Recommendation Report for Planning Permission

REF NO: FG/19/21/PL

LOCATION: First Floor Flat
60 Ferring Street
Ferring
BN12 5JP

PROPOSAL: Change of use of flat above restaurant to a bar. This site is in CIL Zone 4 (Zero Rated) as other development.

TITLE	PROPOSED FIRST FLOOR PLAN & PARTY WALL TREATMENT DETAIL
-------	--

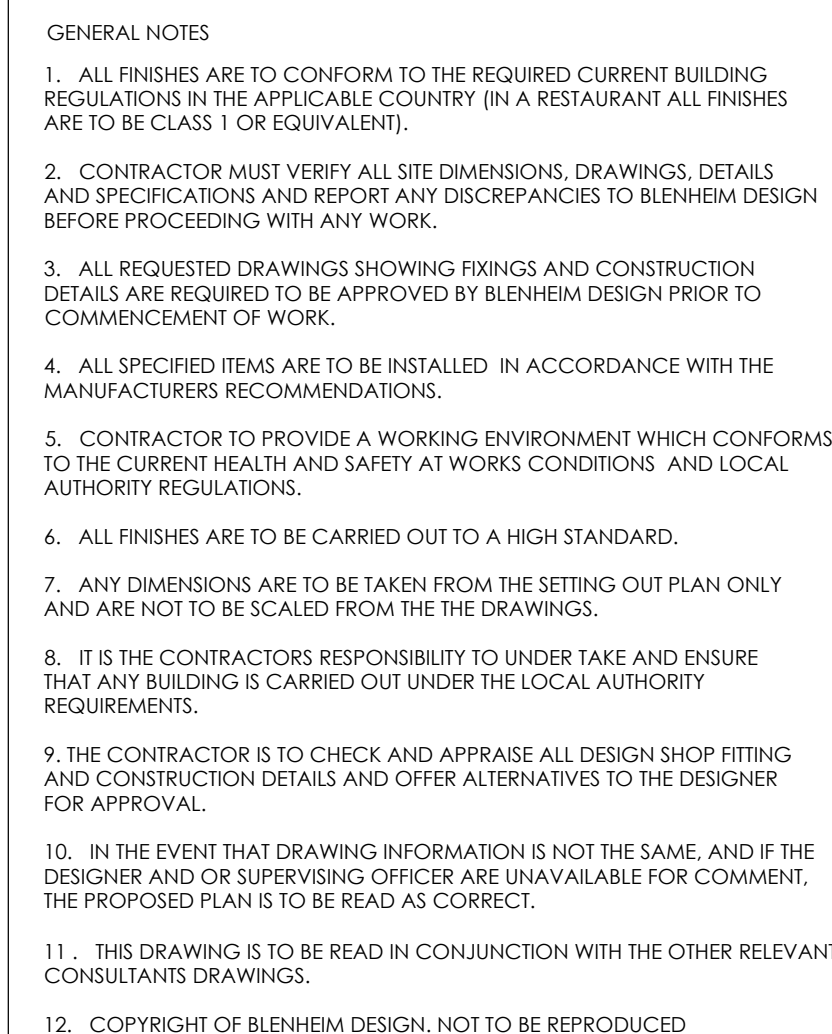
There are other residential premises at first floor in adjoining properties. A scheme of noise insulation is proposed that would see plaster board and noise insulation panels attached to the existing walls. It is necessary to condition that this scheme of noise insulation is installed prior to the use at first floor. There is no external customer areas proposed or included within this application.

- 4 Prior to the occupation of the premises, the proposals shown on the approved drawings for the insulation of noise for the first floor shall be implemented in full and thereafter be permanently maintained.
